# ENG-EGP20007-R2-GEC.pdf Markup Summary

(Note that comments on Sht 2 are the same comments submitted to EDARP on 11/16/2021 for EGP207)

OVERLOT GRADING & EROSION CONTROL PLAN

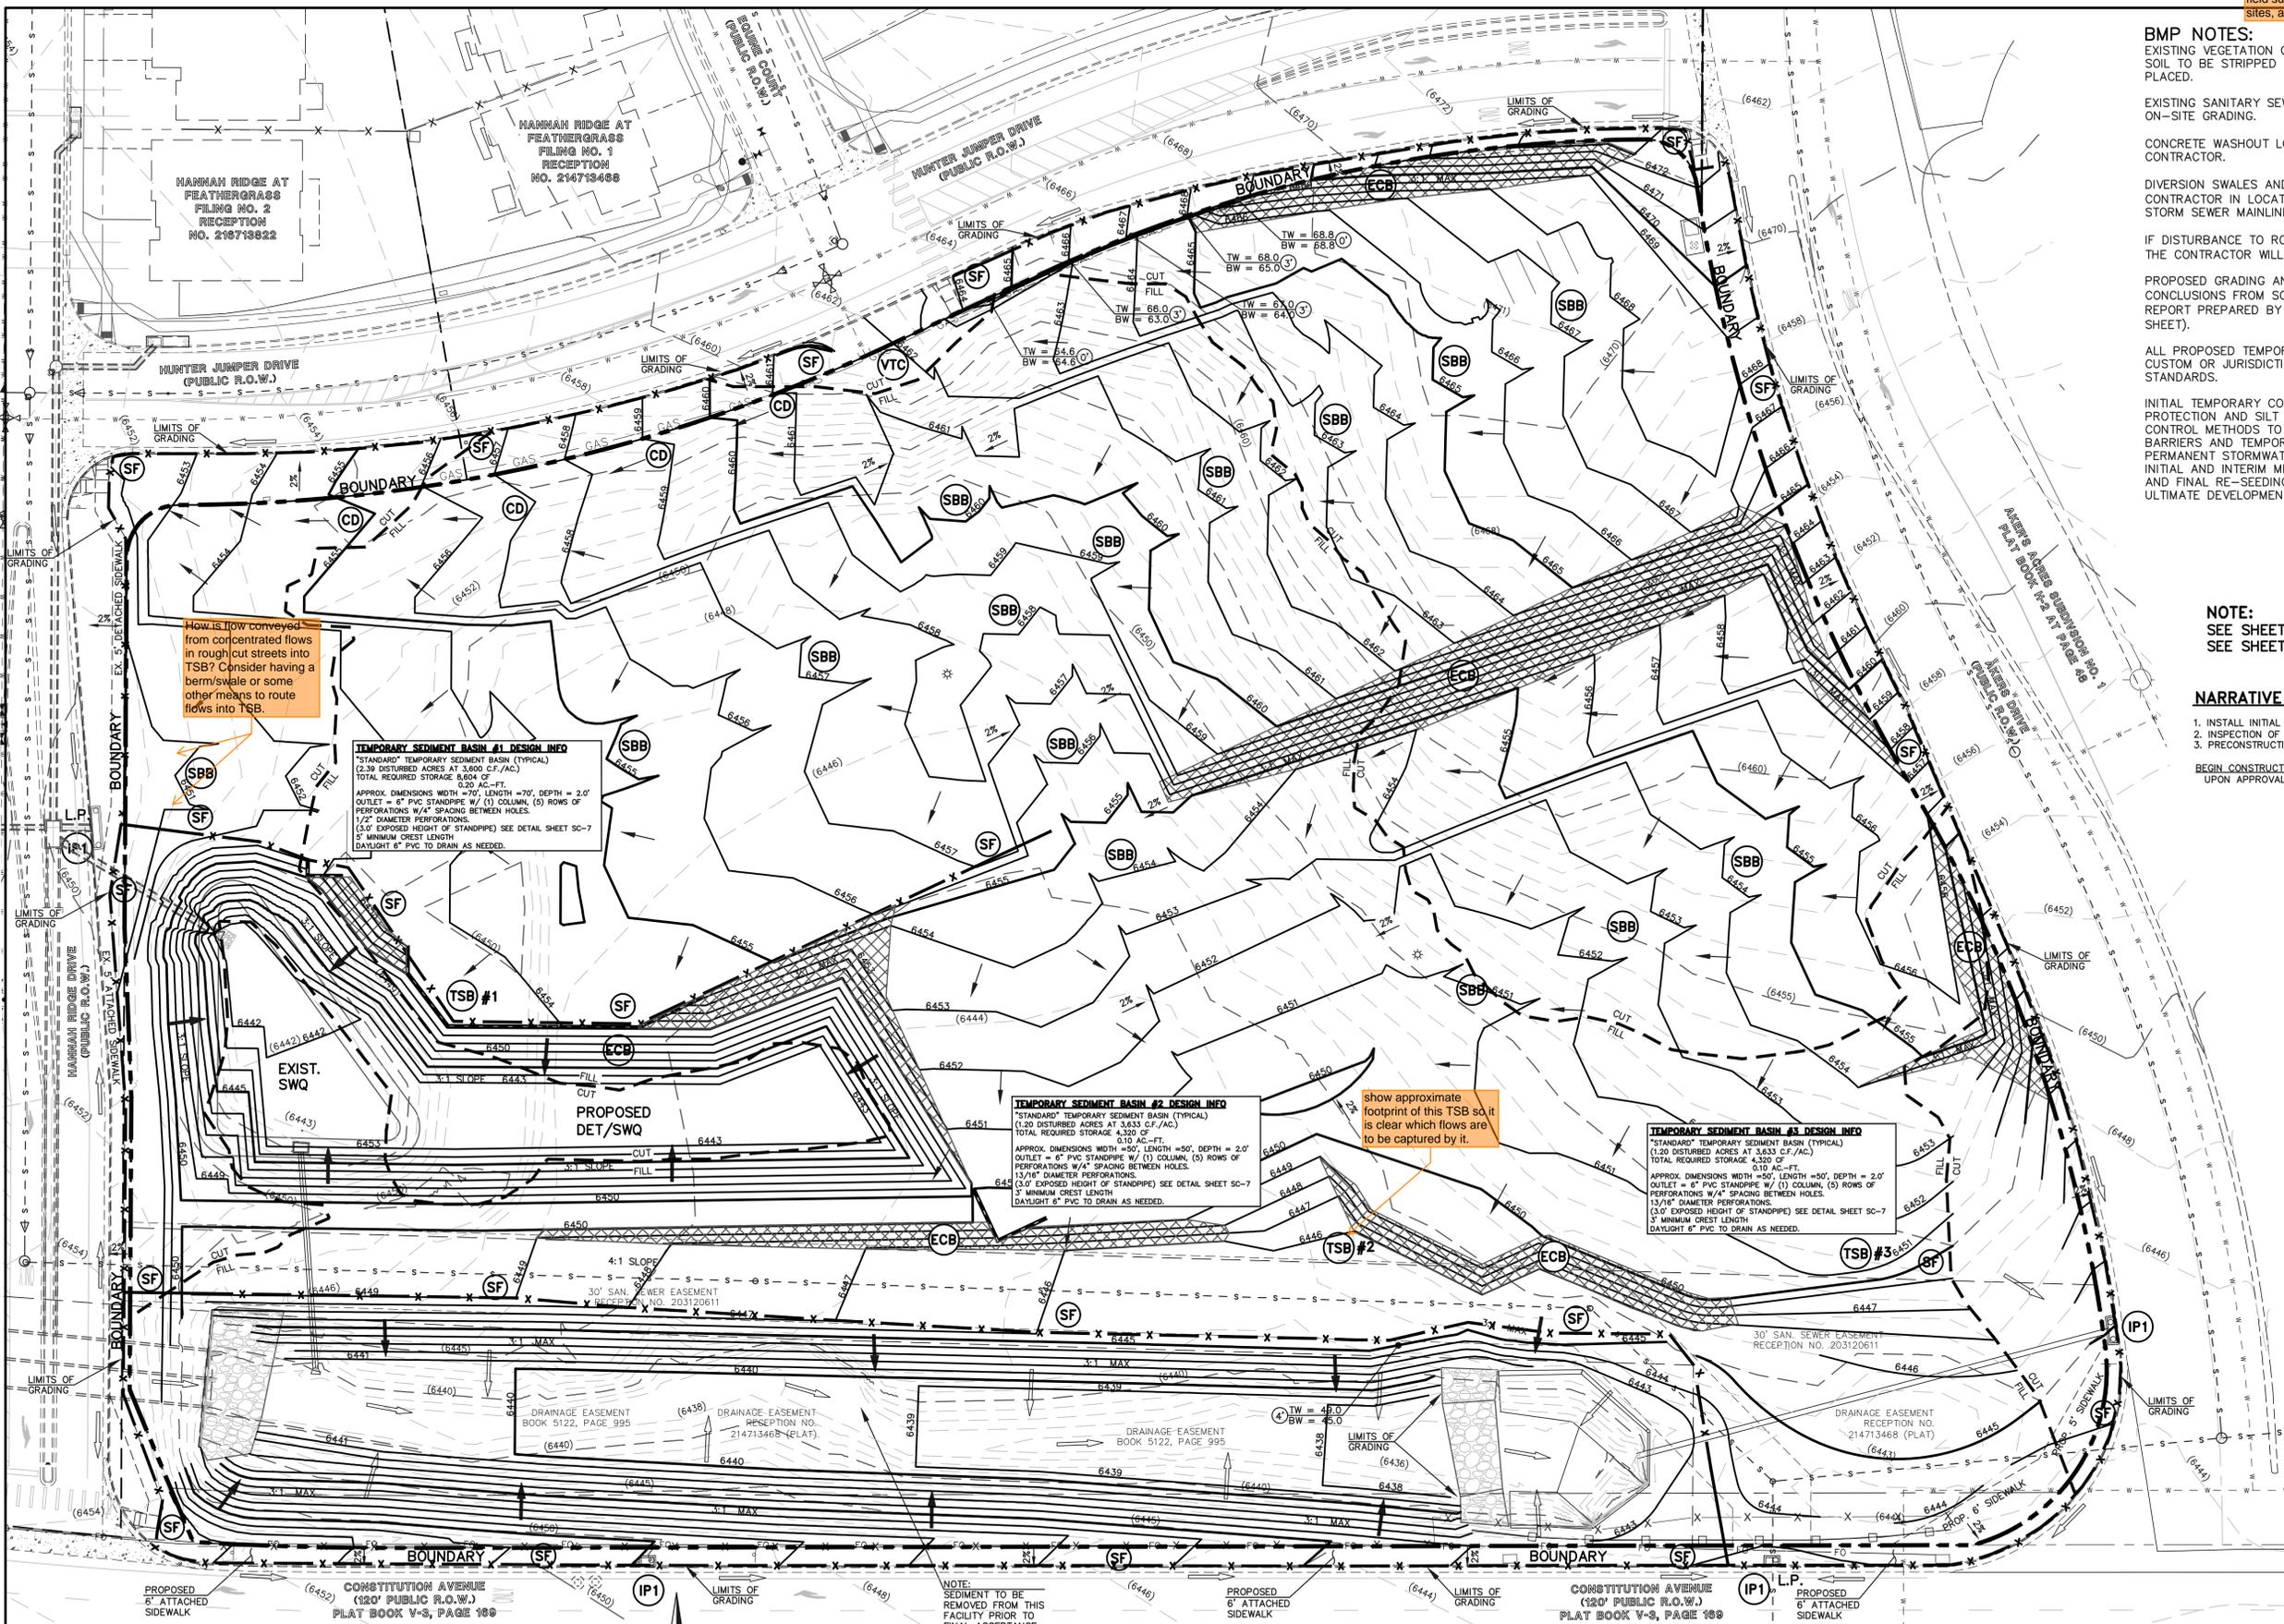
Delete labels, as not part of Early Grading

Hard to tell where these easements are.

Add some text like: "developer/contractor to decide locations in the field such the concentrated flows will be prevented from exiting the sites, and rather directed towards TSB's."

How is flow conveyed from concentrated flows in rough cut streets into TSB? Consider having a berm/swale or some other means to route flows into TSB.

show approximate footprint of this TSB so it is clear which flows are to be captured by it.

Walls are not approved as part of early grading. separate from the gas main as appropriate.
